# **SUBMISSIONS REPORT**

SSDA-10448 Mod 2  
Aspect Industrial Estate

Prepared for  
**MIRVAC**

This Submissions Report relates to the Modification to the Aspect Industrial Estate (**AIE**) Development (SSD-10448) at 804-882 Mamre Road, Kemps Creek (**the site**). On behalf of Mirvac Projects Pty Ltd (**the Applicant**), this Submissions Report has been prepared to address the matters raised by public agencies, local Council and other relevant stakeholders throughout the public exhibition period.

Drawing Name:
Landscape Plan
Lot 1

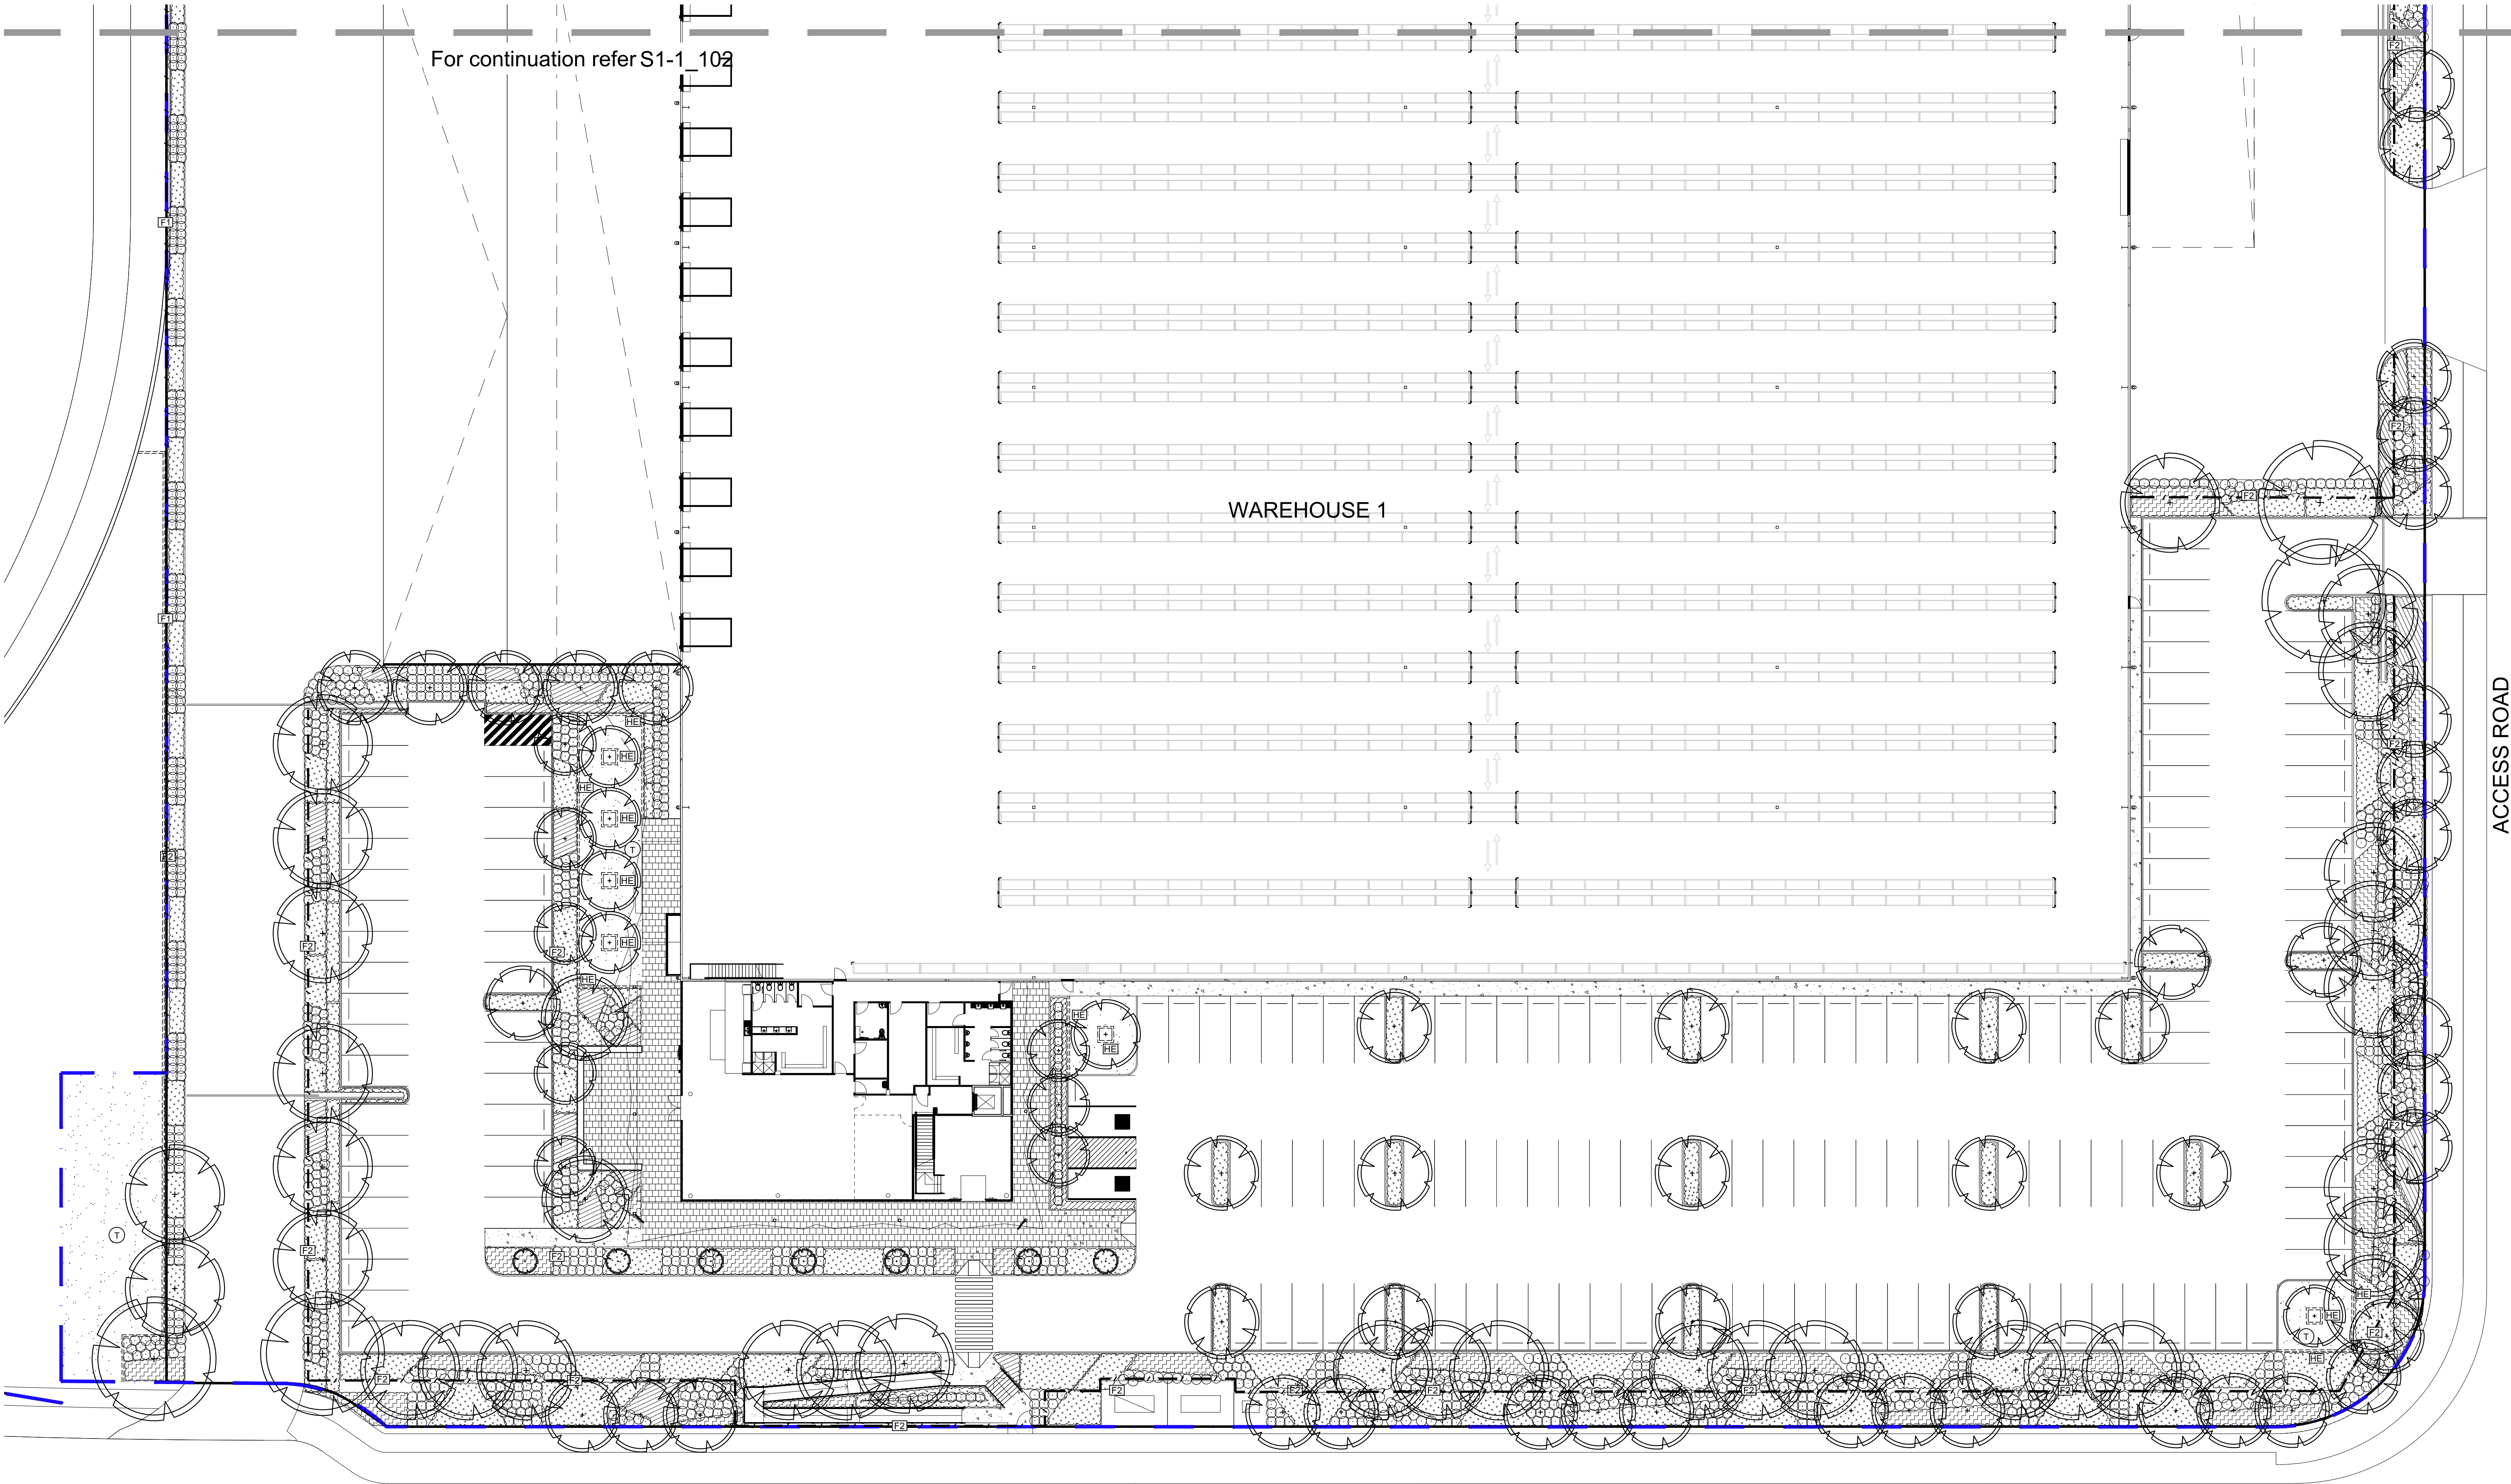
Summary of Issue Raised	Response	Supporting Document
<b>Landscaping</b>		
Council has previously raised that landscaping along the Mamre Road frontage and along the frontage to Warehouse 1 is unachievable when reviewed against the civil sections. The EIS does not adequately respond to this matter.	The refined landscape plans and masterplan have been prepared to be consistent with the latest architectural plans and civil drawings.	<b>Appendix C</b>
<p>(d) The landscape master plans accompanying the application propose 18 x Spotted Gums being a mature height of 30m with a canopy spread of 8m.</p> <p>Spotted Gums shown on the Tree Planting Masterplan S1-1 001 Rev A are not indicated on the Lot 1 on-lot works landscape plans (refer S1-1_101 through 103 revision P and Figures below).</p> <p>Previously provided section through this area have been removed from the civil and landscape sets.</p>	<p>The plan and figure referenced in this commentary is outdated. This plan submitted to Penrith City Council is outdated and included in the application package by mistake.</p> <p>See extract of updated landscaping for Lot 1 at the vehicle entrance from Access Road 1 below.</p>	<b>N/A</b>

Summary of Issue Raised	Response	Supporting Document
 <p><b>Figure 7:</b> Applicant's Landscape plan – Warehouse 1 – 05 refers to Spotted Gums</p>  <p><b>Figure 8:</b> Applicant's On-Lot Works Landscape plan – Warehouse 1 – Excerpt.</p> <p><b>Figure 9:</b> Civil plans indicating no space for canopy tree planting (refer 18-596-C2143 issue I)</p> 		
<p>Notwithstanding the above, trees are not achievable in the selected location upon review of the sections and owing to the location of the palisade fencing, the retaining wall, and the super awning above.</p>	<p>The refined landscape plans and masterplan has been prepared to be consistent with the latest architectural plans and civil drawings.</p>	<p><b>Appendix C</b></p>

LOT 3 SITE & WAREHOUSE FLOOR PLAN

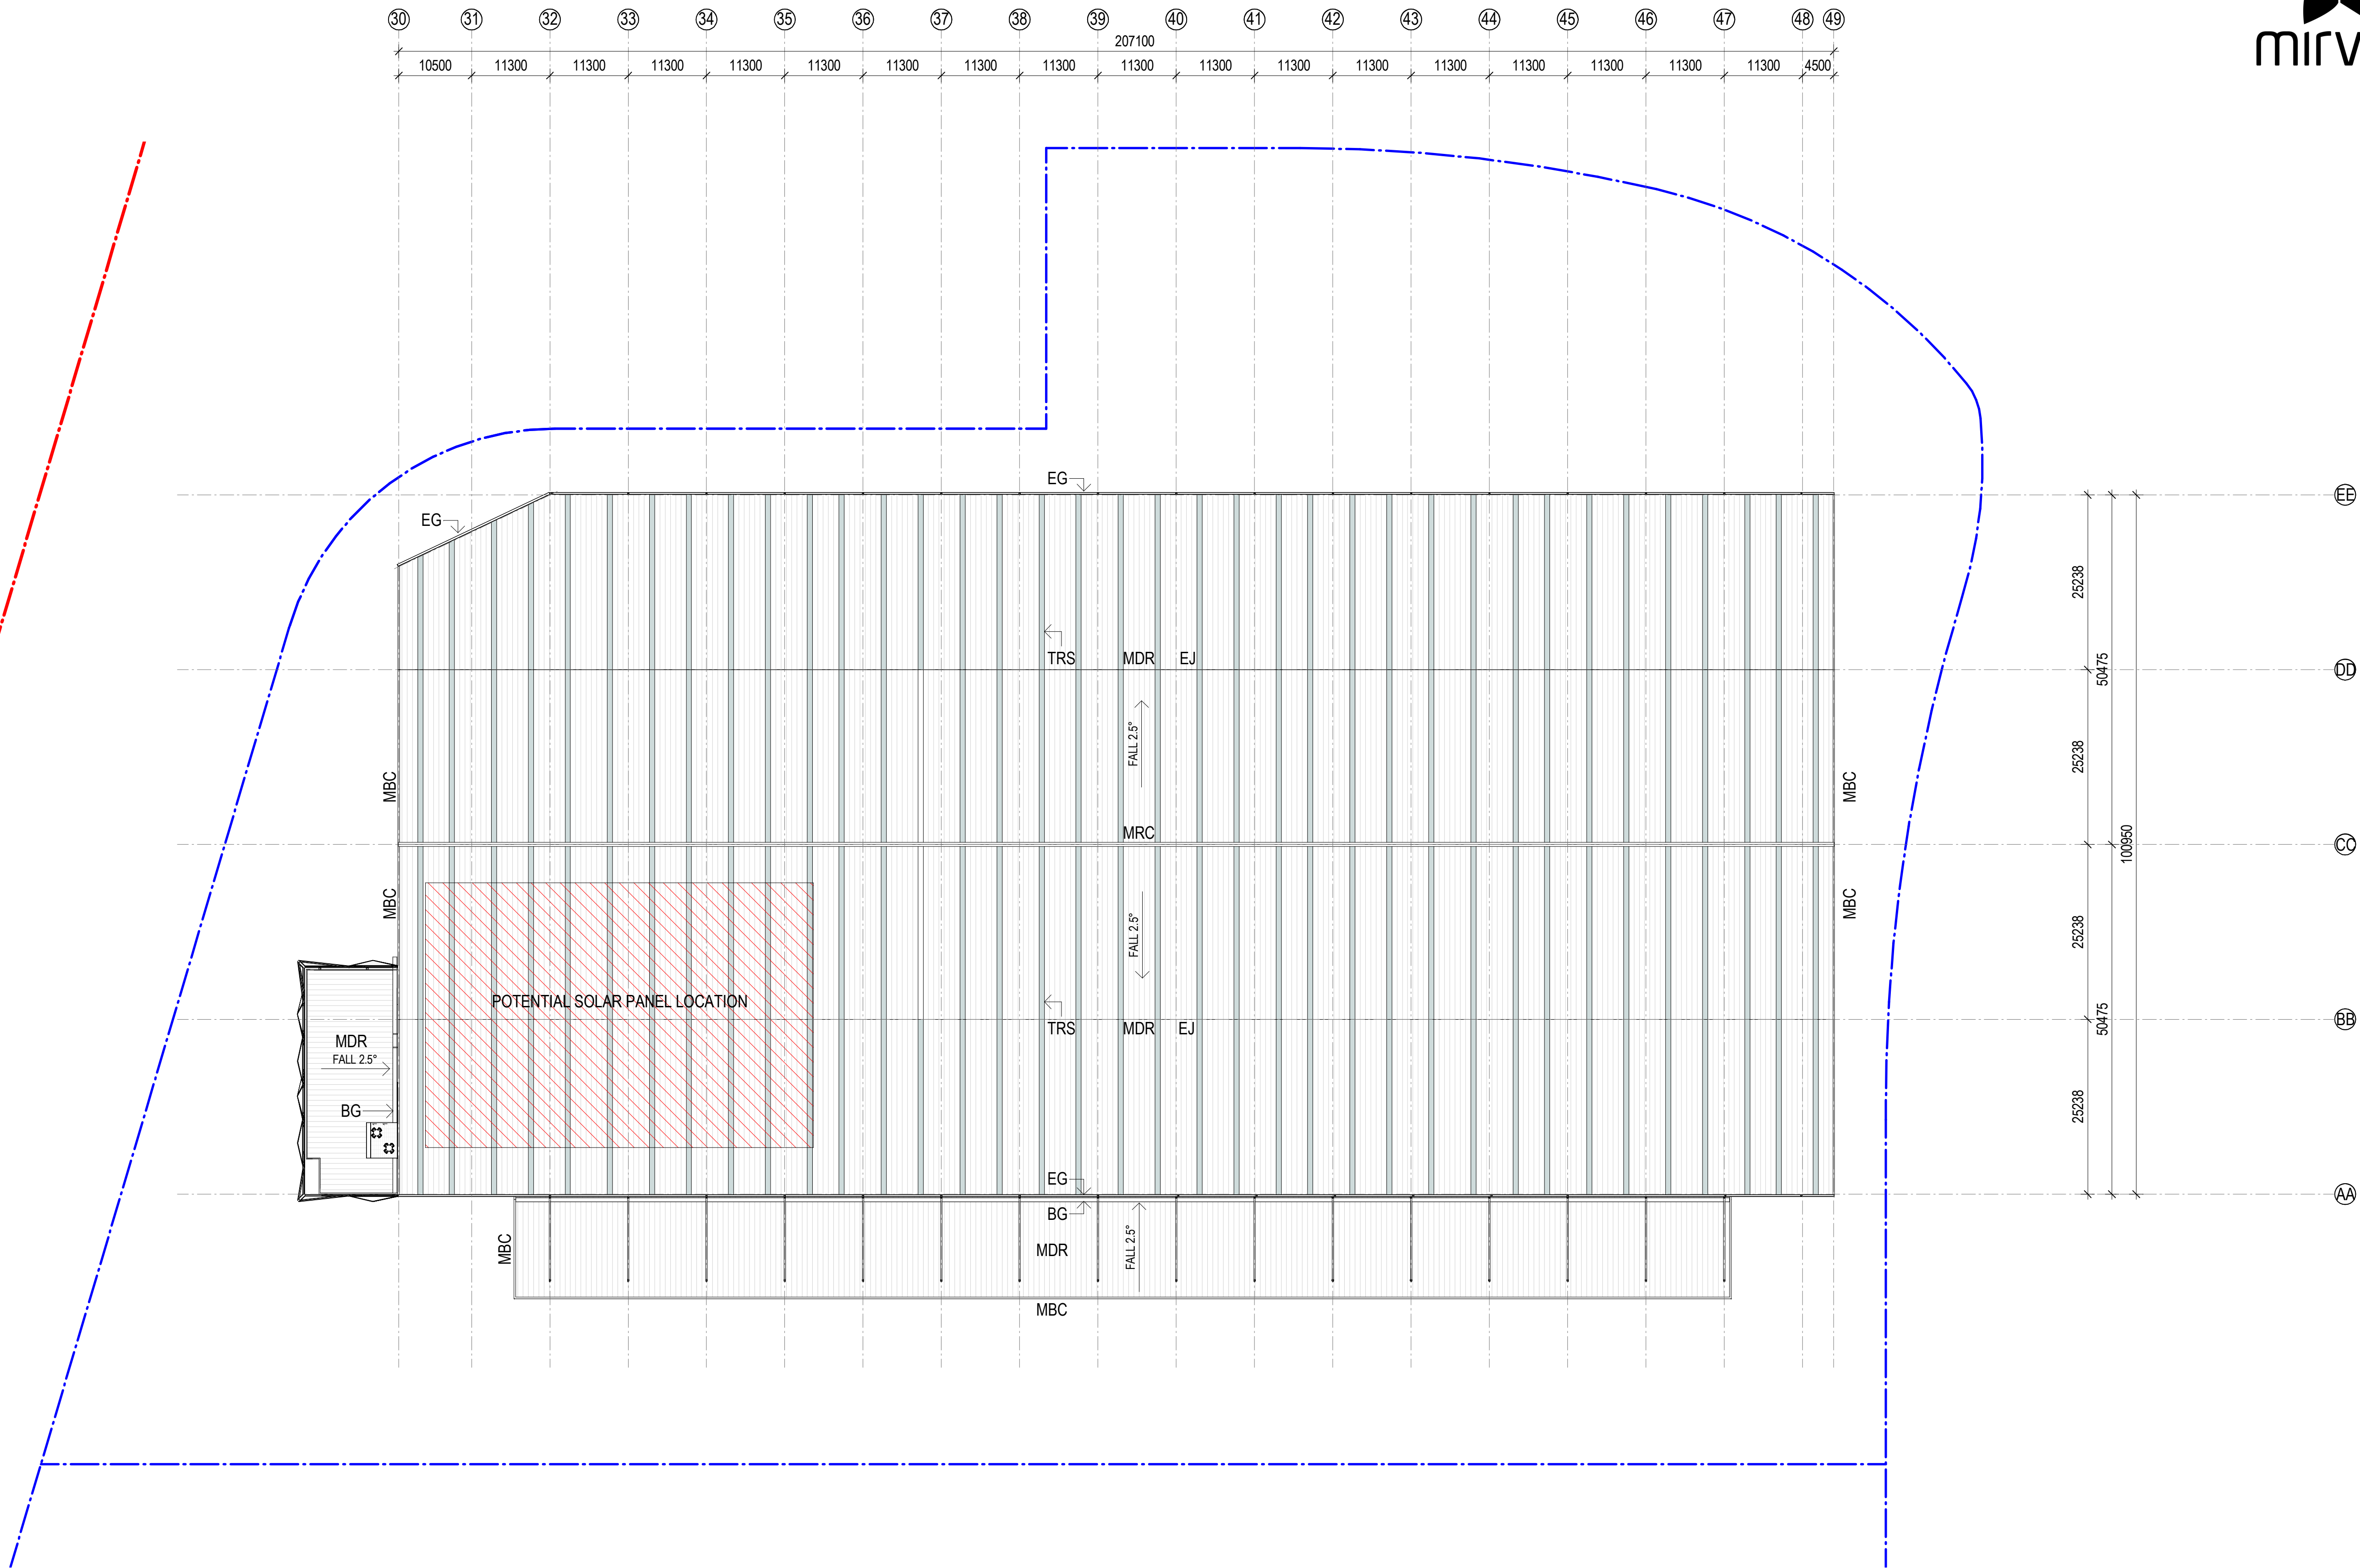
Summary of Issue Raised	Response	Supporting Document
<p>The concept plans indicate that no right turn into the staff and visitor driveway will be available owing to the location of the roundabout pedestrian safety refuge.</p>	<p>The location of the Warehouse 3 south east access crossover has been adjusted and will provide greater separation from the pedestrian safety refuge. This access crossover will be restricted to Fire Brigade only in the event of an emergency.</p>	<p><b>Appendix A</b></p>
<p>The 27 staff parking areas located along the eastern side of Warehouse 3 are too far removed from the entry point for workers. And no safe separated pedestrian pathway is provided along the private driveway.</p> <p>The EIS includes that a future, adjusted version of the architectural plans will include a 1.5m wide pedestrian pathway that will facilitate safe travel from the carpark to the office, separated from the roadway. It is recommended that DPE seek submission of this plan and that it forms part of the approved documents, should consent be granted.</p>	<p>The number of parking spaces located along the eastern side of Warehouse 3 has been reduced to 21 spaces and the parking spaces has been relocated to the north car park on the refined plans, which closer to the warehouse entry point. This provision is now substantially reduced from the 36 spaces approved under SSD 10448 The refined proposal is an improvement on the SSD10448 approval.</p> <p>As per the refined drawings a 1.5m pedestrian pathway has been introduced to cater for staff travelling from the parking area to the office.</p>	<p><b>Appendix A</b></p>

<p>No safe pedestrian pathway is provided for staff and visitors along the northern private driveway for Warehouse 3.</p>	<p>As per the refined drawings, a pedestrian pathway has been provided for access from the crossover on Access Road 02 to Warehouse 3.</p>	<p><b>Appendix A</b></p>

<p>It is reiterated that heavy vehicles be fully separated from staff and visitor vehicles.</p>	<p>The refined plans demonstrate that there will be distinct, separate travel paths for heavy and light vehicles to Warehouse 3. The refined lot boundaries and driveway alignment facilitates a swept path analysis on the master plan drawing that confirms that trucks will not cross the into oncoming cars entering the carpark.</p> <p>The updated Traffic Impact Assessment (TIA) report includes a swept path assessment which demonstrates the driveway design will facilitate separated paths of travel.</p>	<p><b>Appendix A and F</b></p>
